# Memorandum

**SUBJECT:** MODIFICATION APPLICATION FOR RESOURCE RECOVERY  
FACILITY AT 35-37 FRANK STREET, WETHERILL PARK

**FILE:** SSD 7256 MOD 3

**DATE:** 30 APRIL 2019

EXISTING DRIVEWAY
SHOWN DOTTED

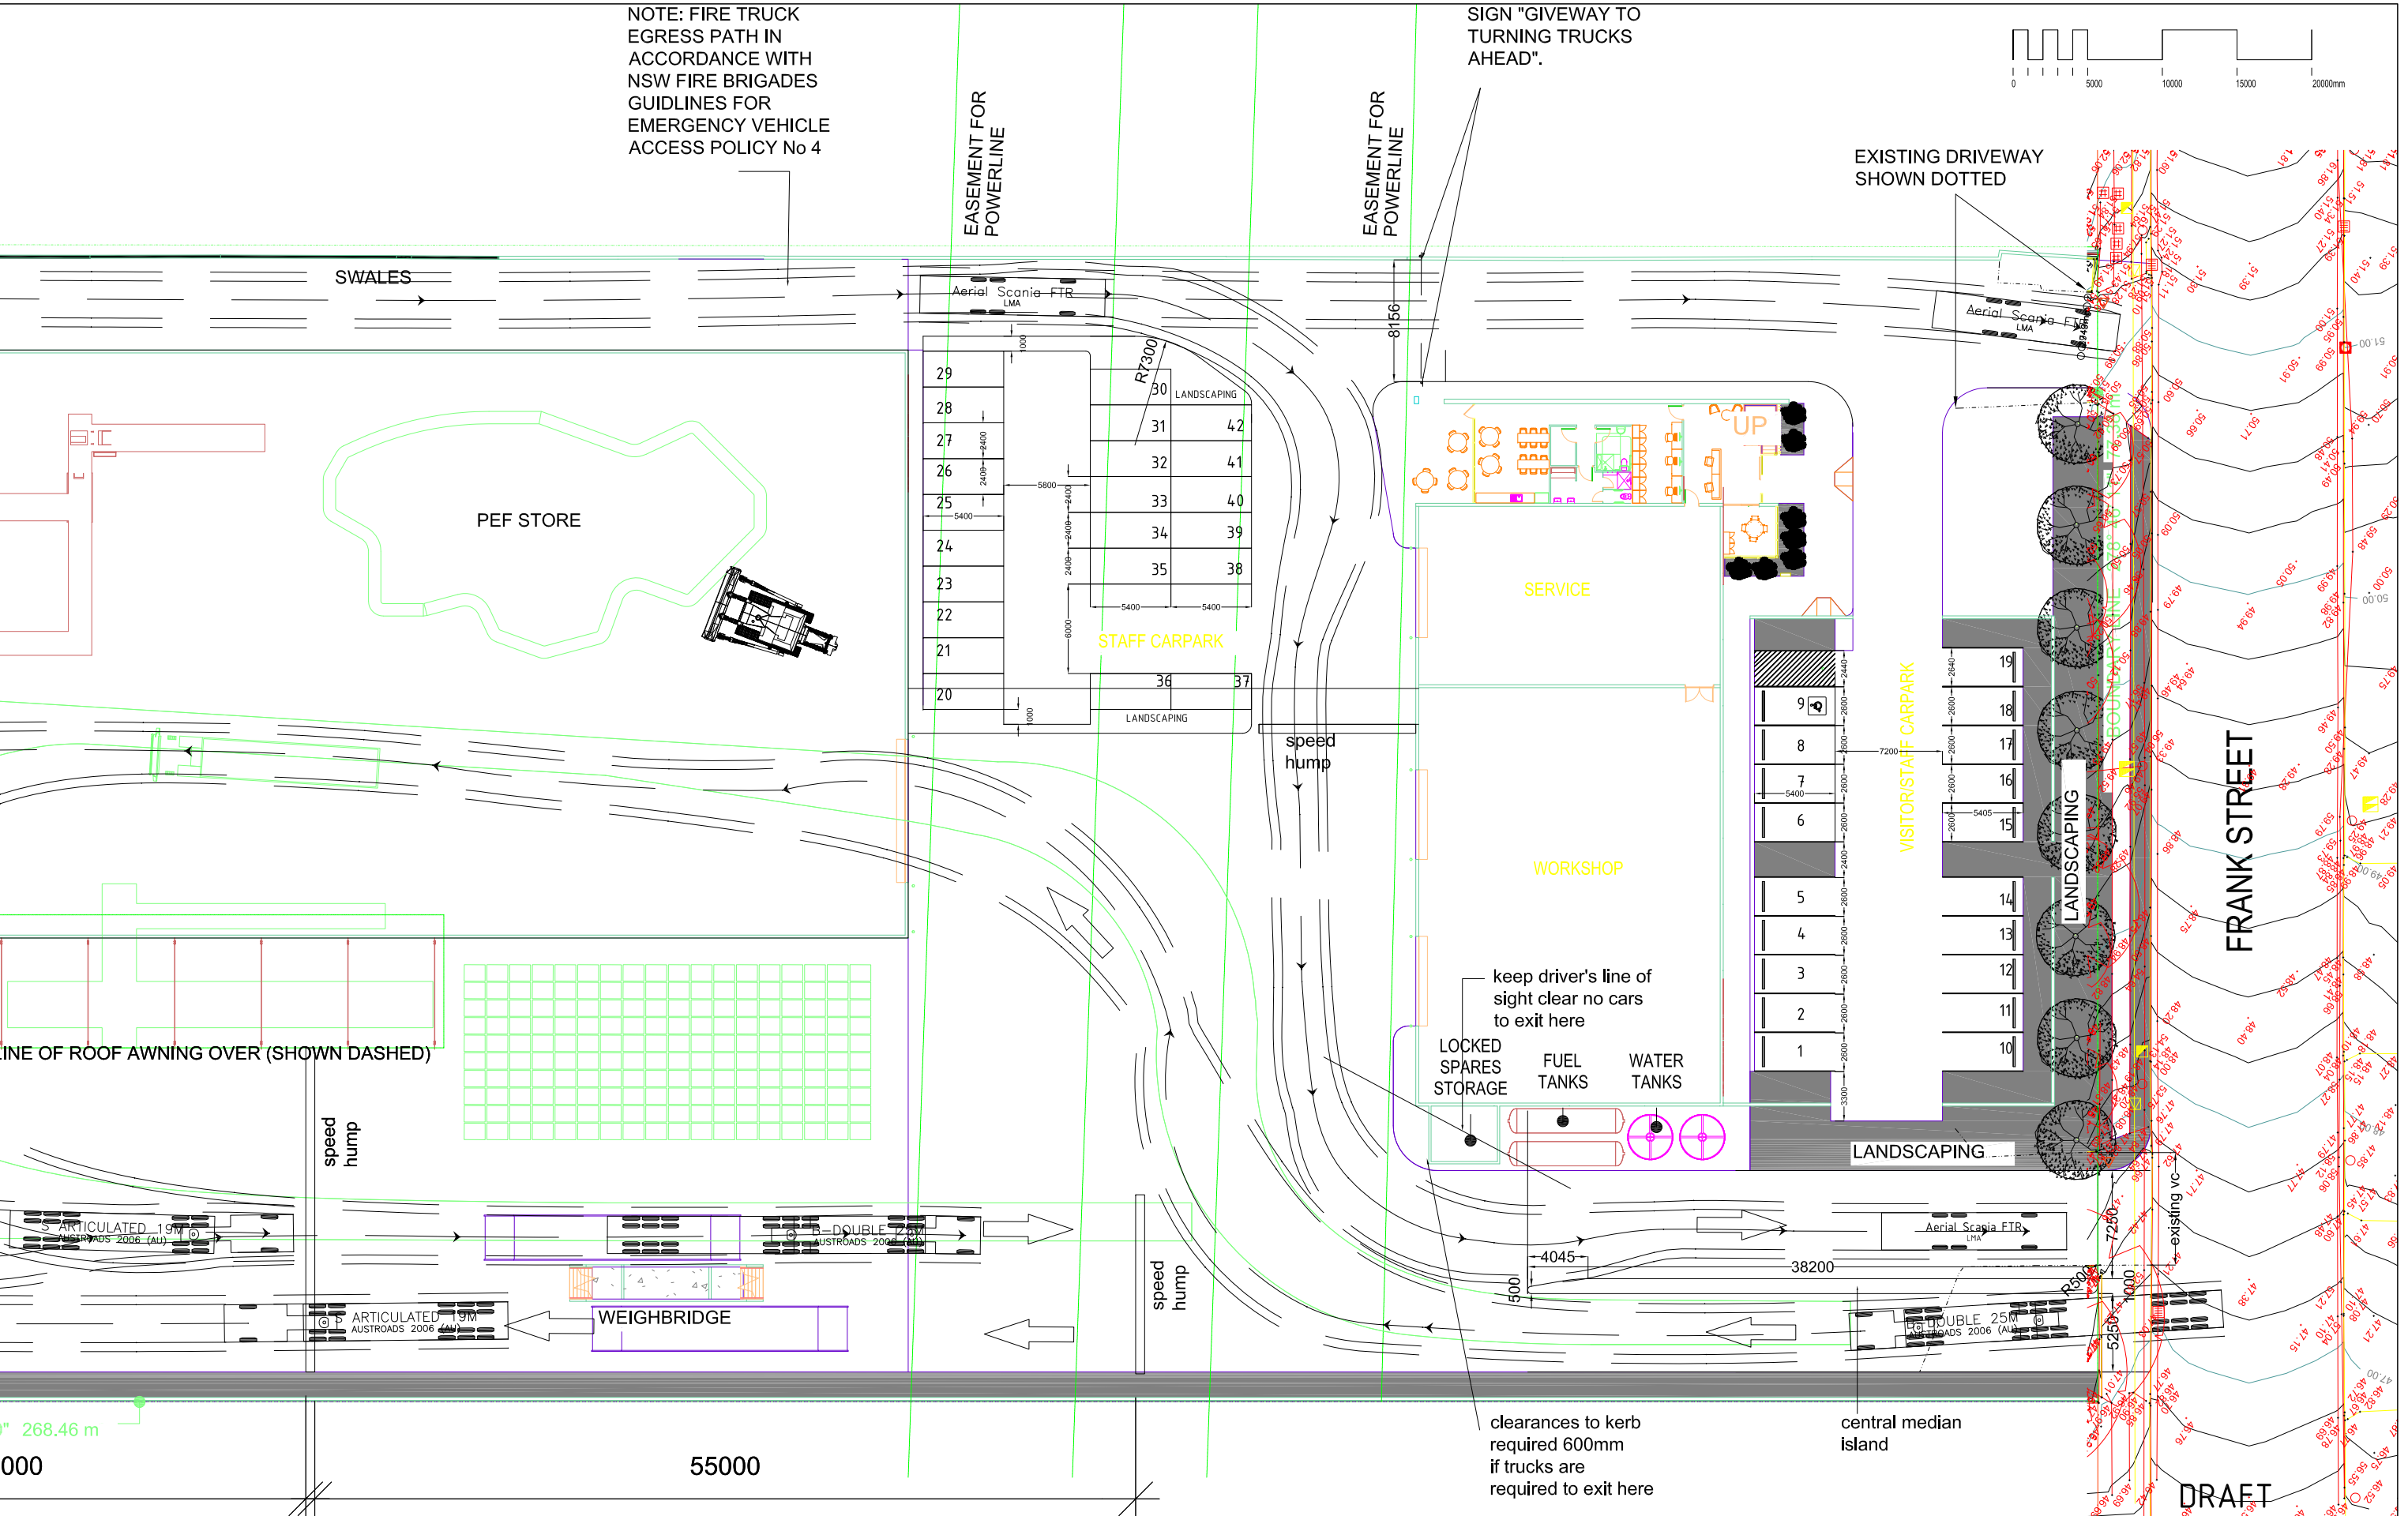
Swept path diagrams provided by the applicant show the manoeuvring of 19m long articulated vehicles and 26m long B-Double vehicles within the site. However, the movements of the articulated and B-Double vehicles manoeuvring into and out of the driveway onto 35-37 Frank Street, Wetherill Park are not shown on the swept path diagrams.

Swept path assessment undertaken by Council officers in accordance with Austroads Design Vehicles and Turning Path Templates shows it would be difficult for the 19m long articulated vehicles and 26m B-Double vehicles to manoeuvre

into the site due to the proposed access arrangement. The swept path diagrams provided by the applicant need to show how 19m long and 26m long vehicles can satisfactorily manoeuvre into and out of the driveway and which direction these vehicles are travelling to/from Frank Street.

The applicant shall also clarify whether the access driveway located on the south-eastern corner of the site will be used by vehicles and/or trucks.
